2023/0007

46 Timothy Wood Avenue, Birdwell, Barnsley, S70 5RX

Erection of conservatory extension to side of bungalow

**PROPOSED CONSERVATORY TO SIDE ELEVATION**  
width 4.25m, projection 3m, hgt to eaves 2.85m, hgt to ridge 3.45m  
brickwork to match property, frames/rafters white upvc, glazing clear, roof material glass

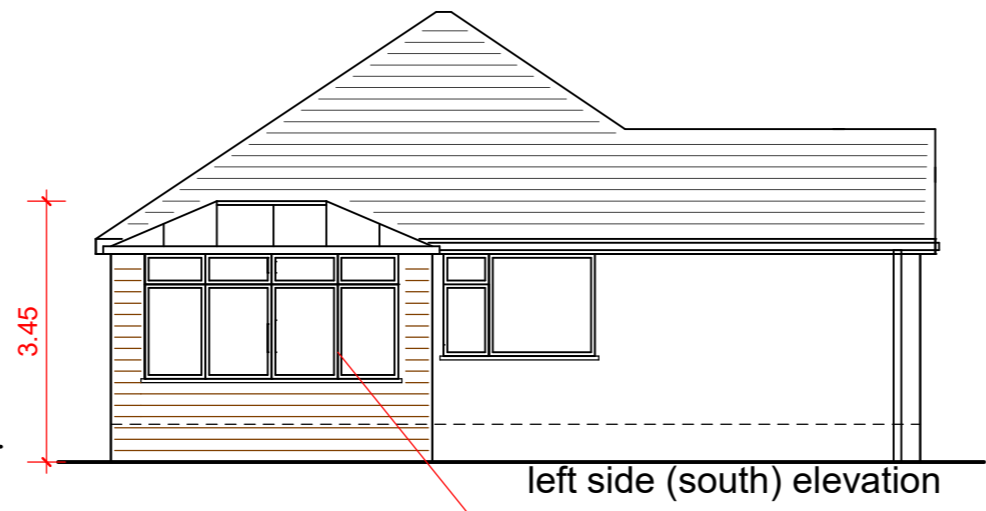
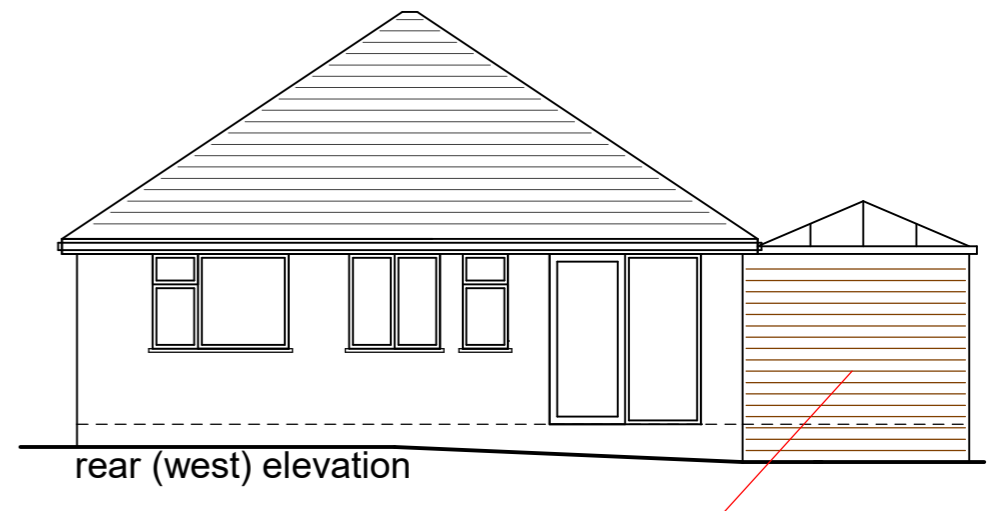
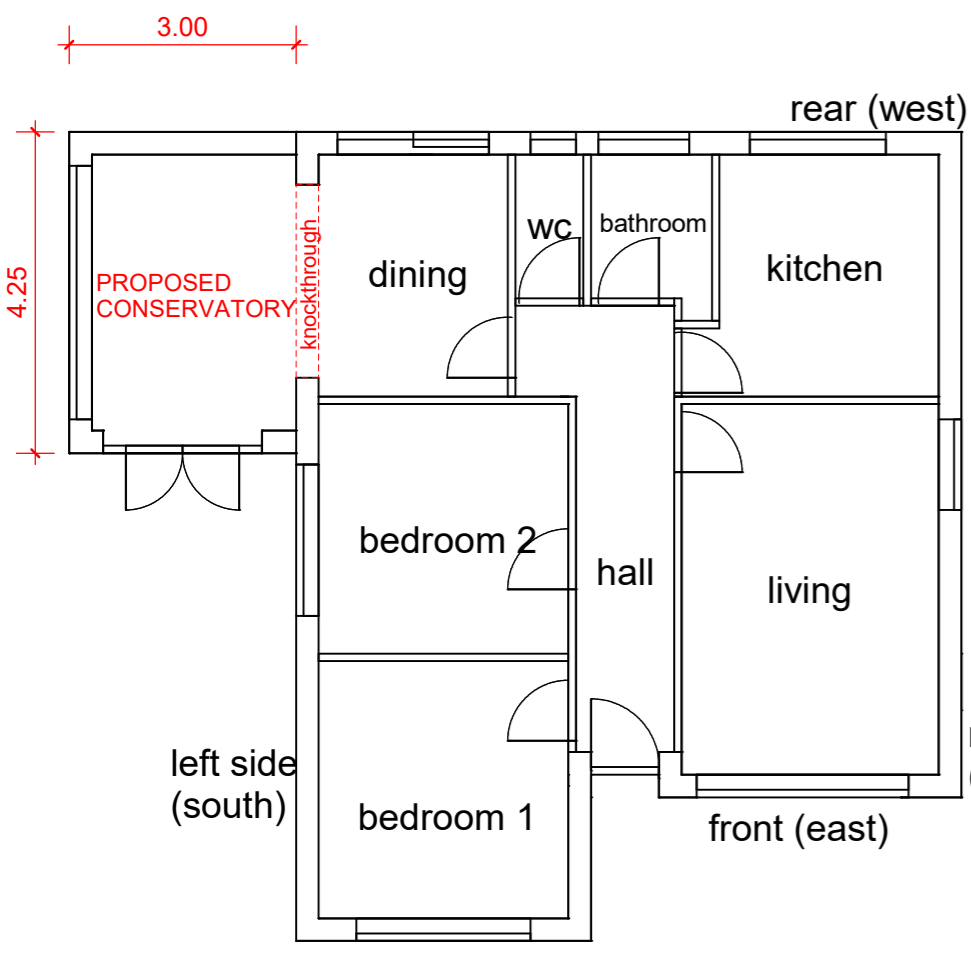
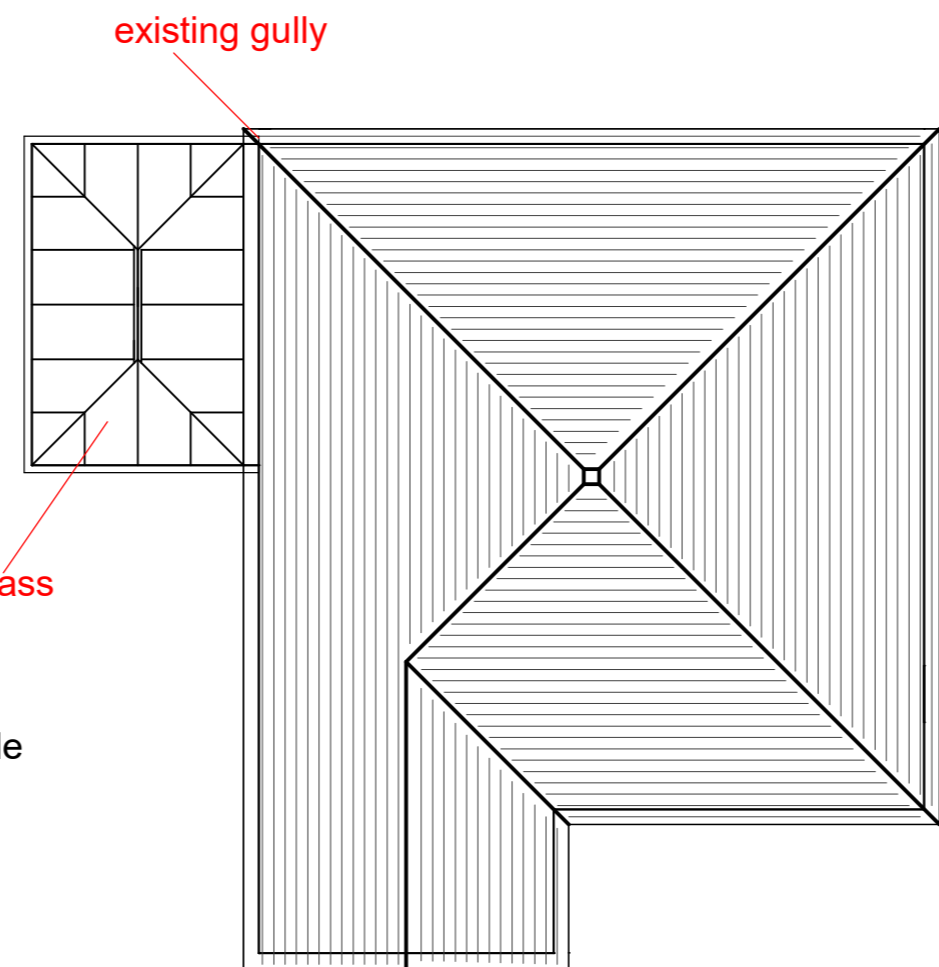
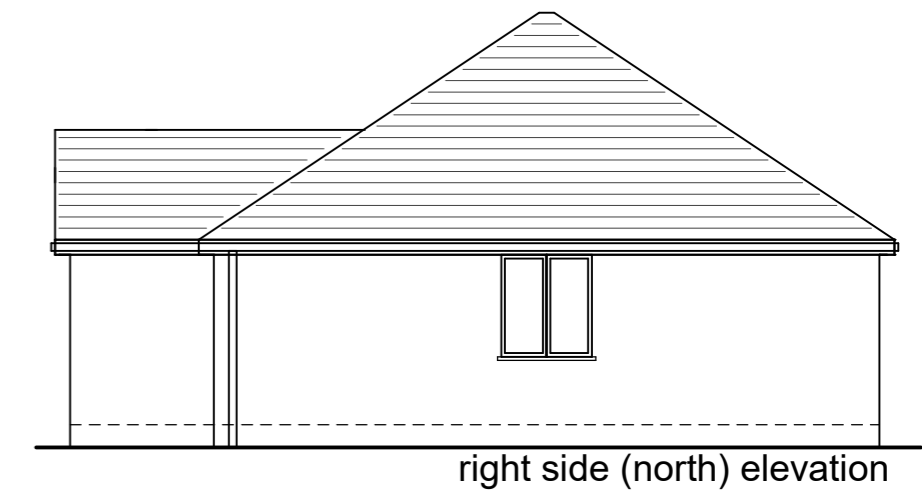
Paragraph 8.15 of the SPD states that ‘where a conservatory abuts a bungalow, because of the level of the eaves it is often very difficult to construct a satisfactory roof slope that creates an awkward relationship between the bungalow and conservatory, as well as a roof junction requiring a valley gutter, which is difficult to access and may give rise to maintenance problems in the long term. It also causes the conservatory to appear unnecessarily high and dominant’, as show in in figure 8.10. This is a close representation of the proposal subject to this application.

The proposals show that the proposed extension would be located to a side elevation within a prominent corner plot. Therefore, the proposed extension would be a prominent feature within the street scene, and as it would abut a bungalow with a relatively low eaves height, an unacceptable and awkward junction between the bungalow and the proposed extension would occur, resulting in

an unnecessarily high and dominant appearance, contrary to SPD – House Extensions and Other Domestic Alterations.

**BLOCK PLAN SCALE 1:500@A4 46 Timothy wood Ave Barnsley S70 5RX**

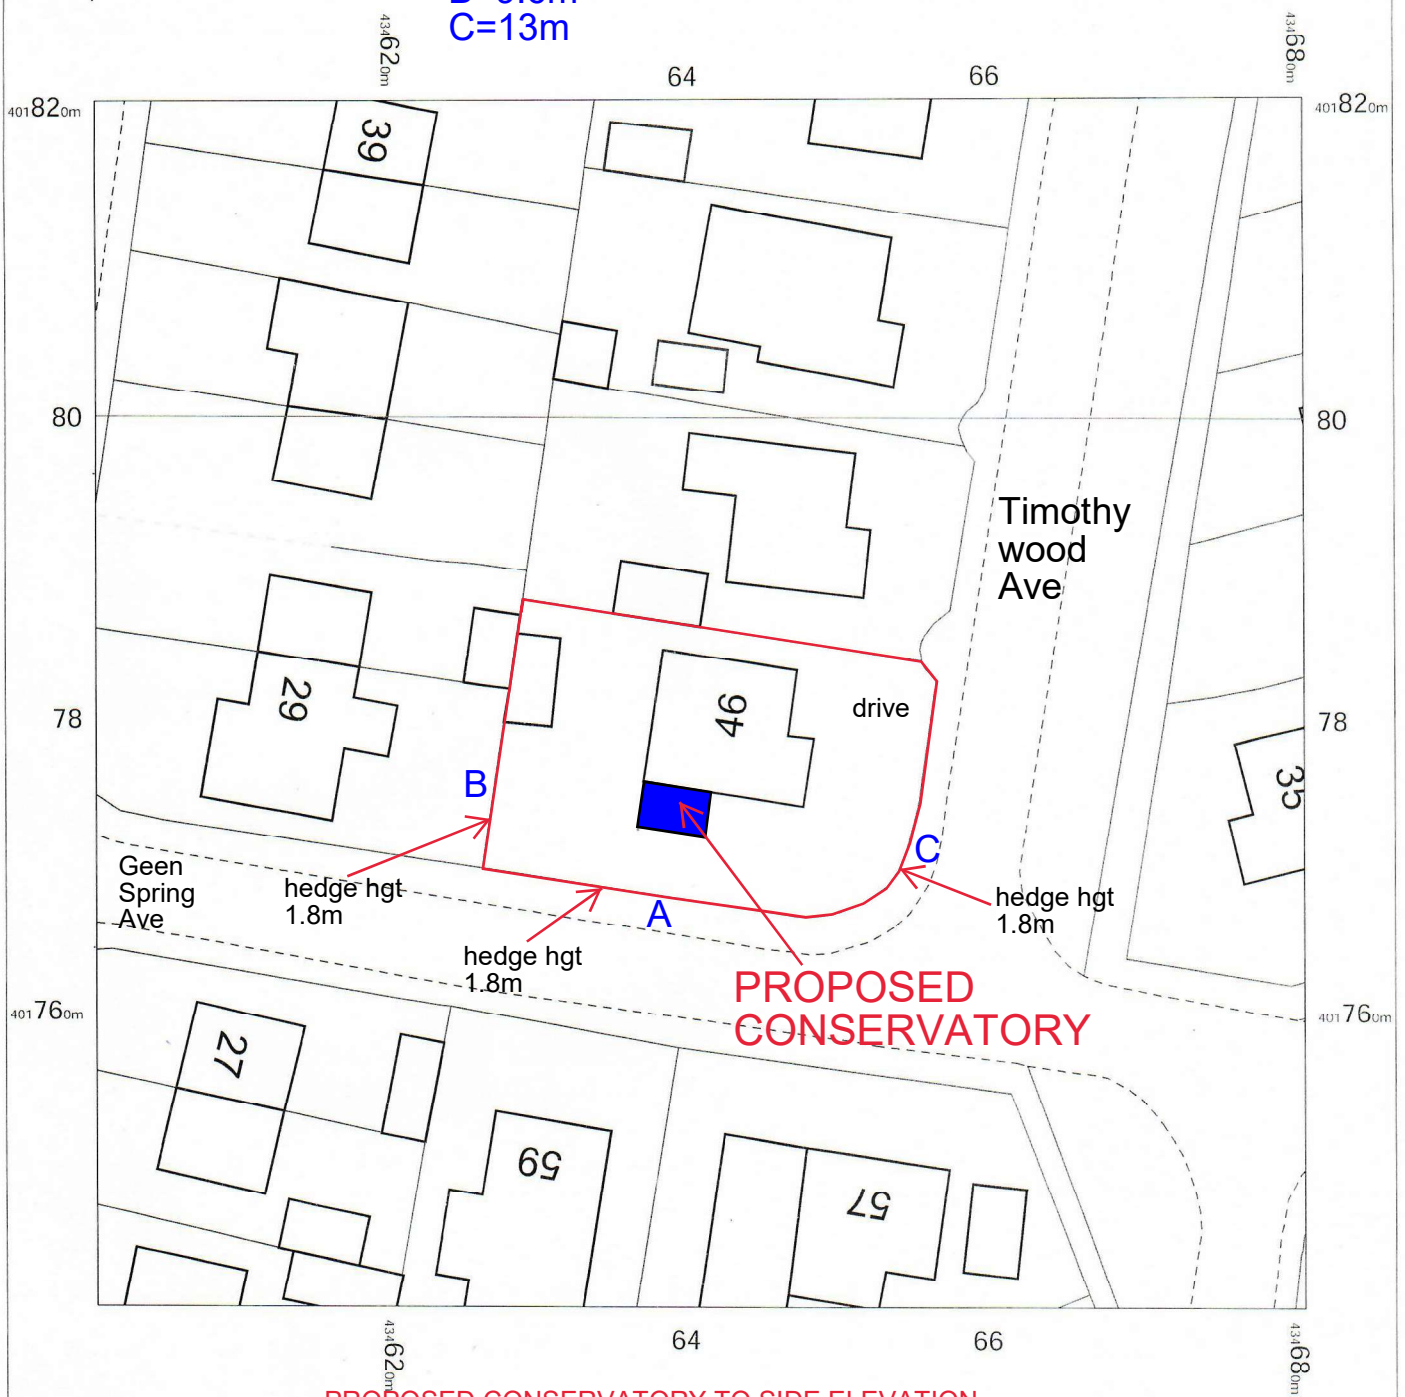
In this instance, the original dwelling would be located approximately 4.2 metres from the boundary located along the back edge of the pavement on Green Spring Avenue. Therefore, the creation of a 3-metre-wide extension would not retain half the existing gap, contrary to SPD – House Extensions and Other Domestic Alterations. Whilst it is acknowledged that the proposed side extension would be set back from the back edge of the pavement for approximately 1.2 metres, it would only be partially screened by existing boundary treatments resulting in the awkward joining between the roof of the proposed extension and original dwelling remaining visible and unnecessarily dominant within the street scene.
